**Subject:** RE: Planning Consultation on EP/9/20/DOC

Further comment from Greenspace

APPLICATION NO: EP/9/20/DOC

Site Address: Green Willow Care Home Vicarage Lane BN16 2SP

Dwg. No. 21628 / 28 / A

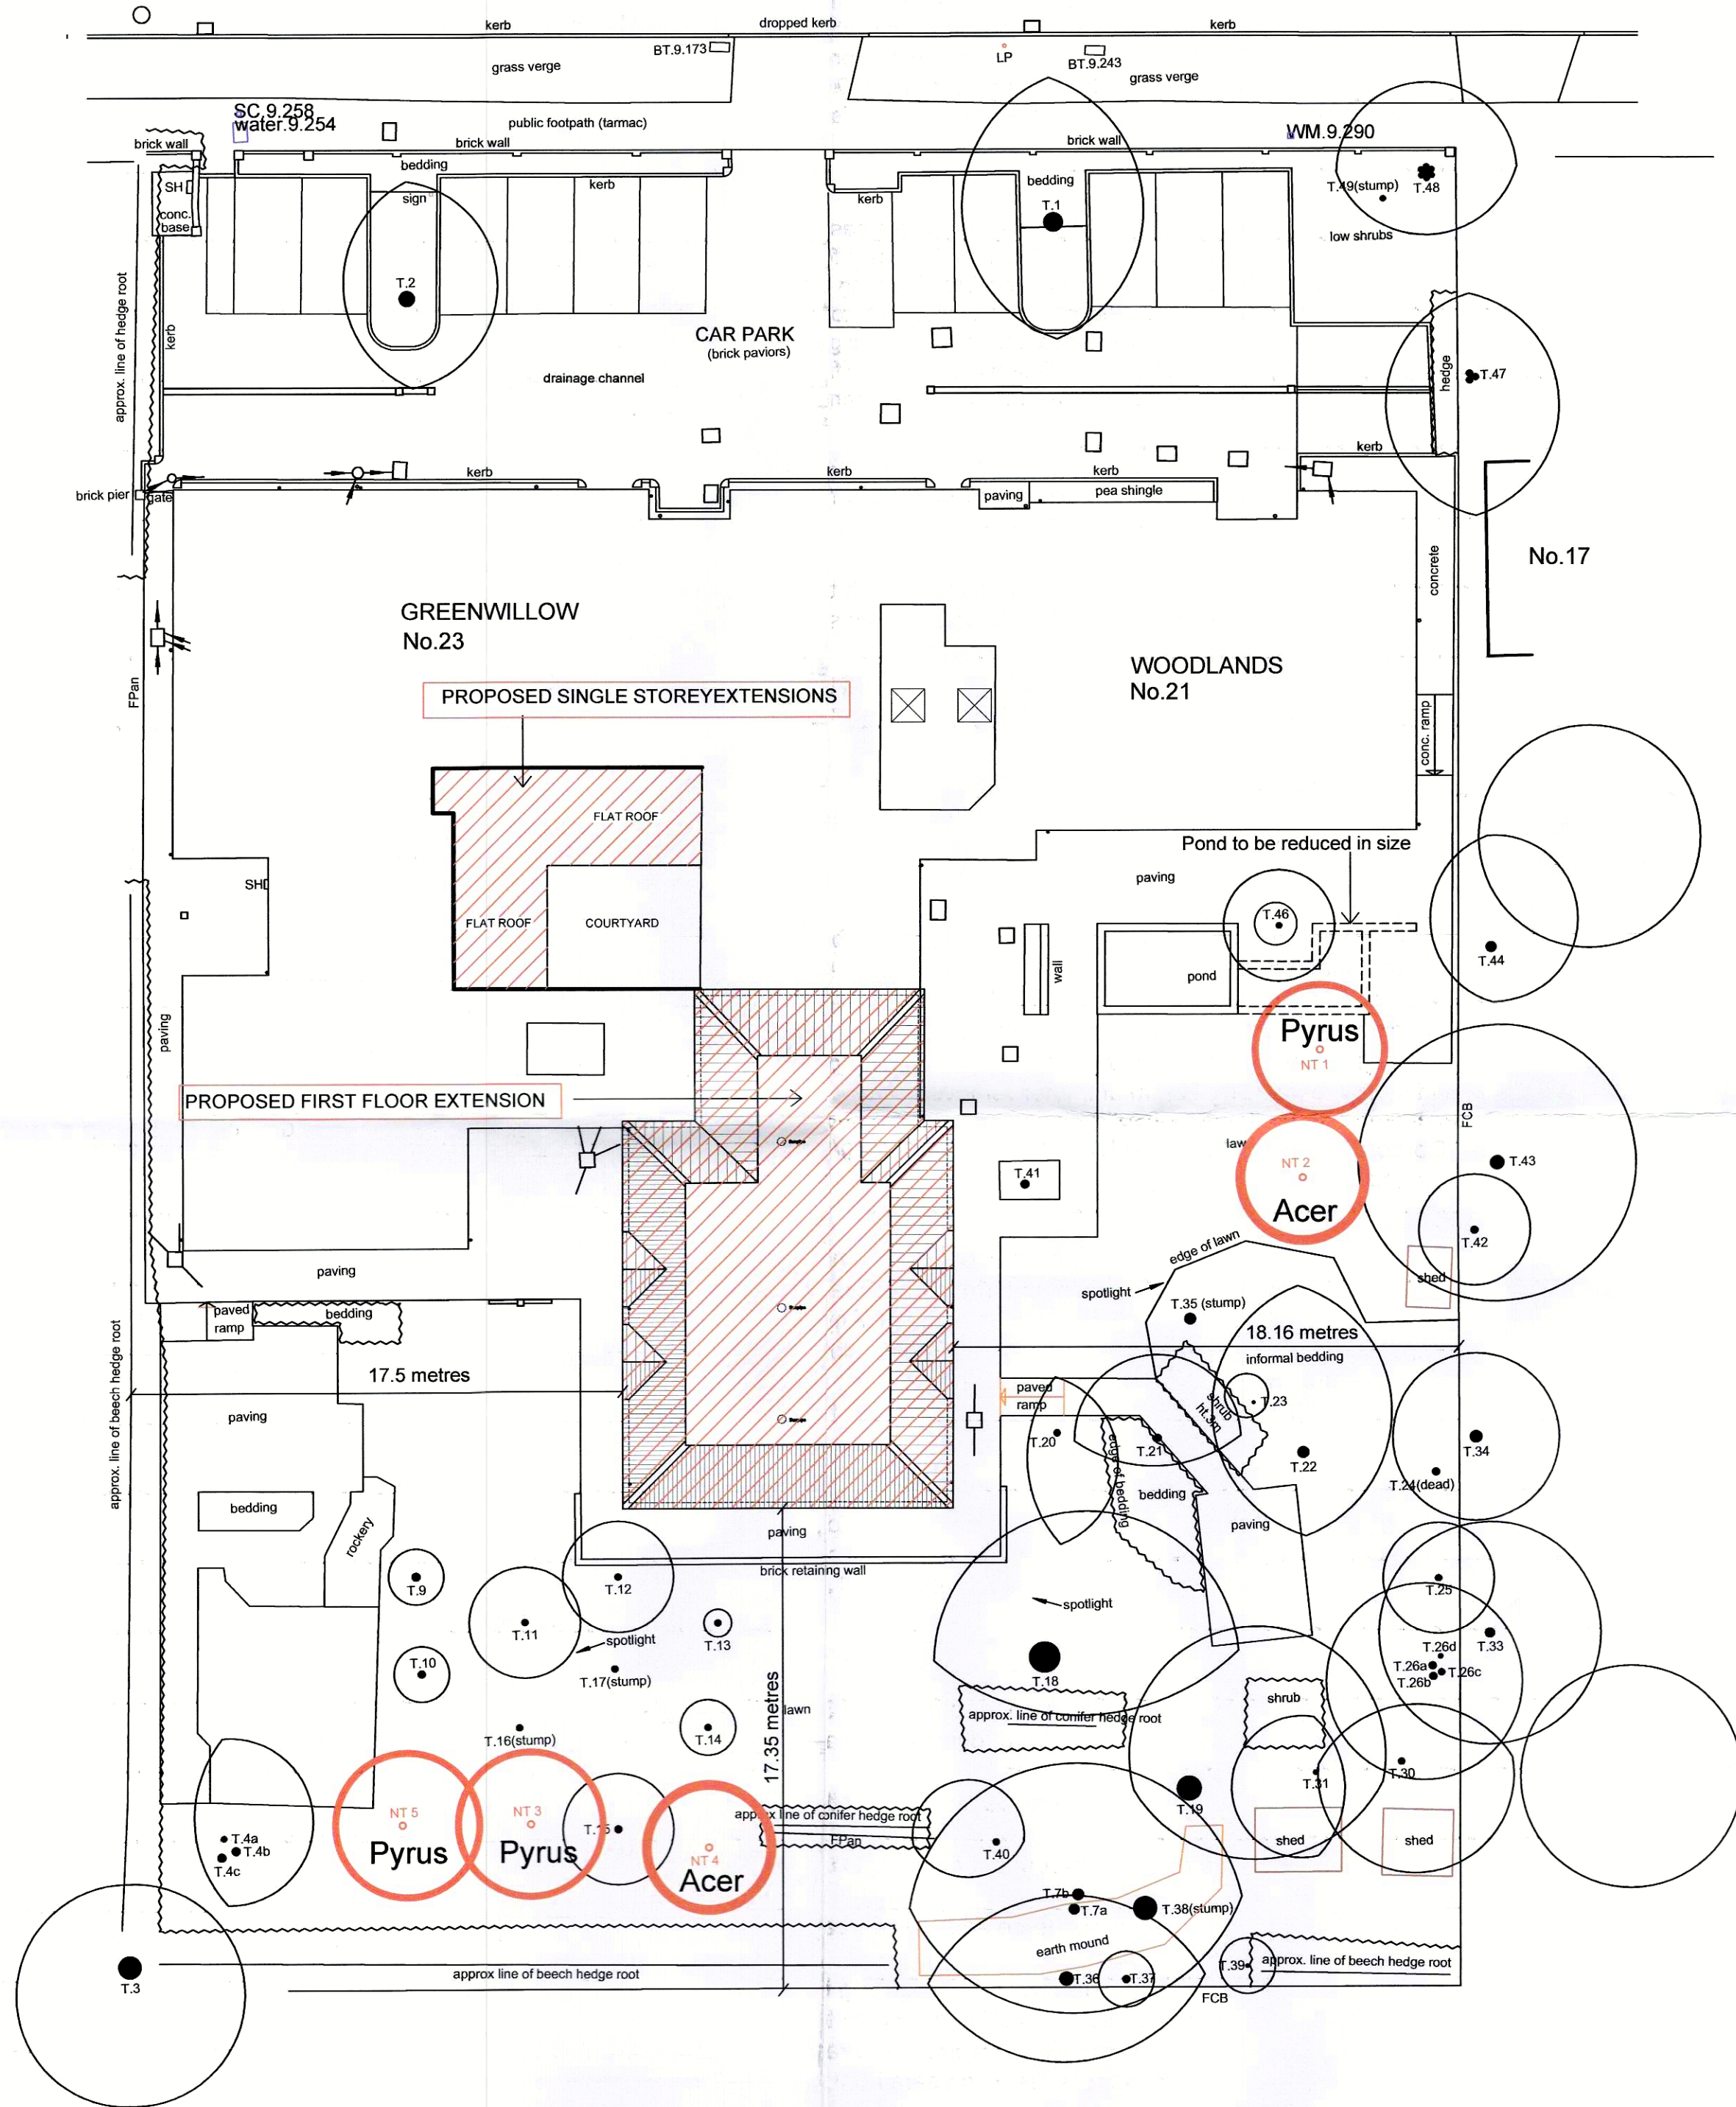
Following submission of revised dwg no 212628/28 rev A, which includes new tree planting proposals detailing species choice and size at time of planting.

I would recommend that the proposals are suitable for location, the information now sufficiently detailed to **recommend the discharge of Condition 7 on this application EP/9/20/DOC imposed under EP/160/16/PL.**
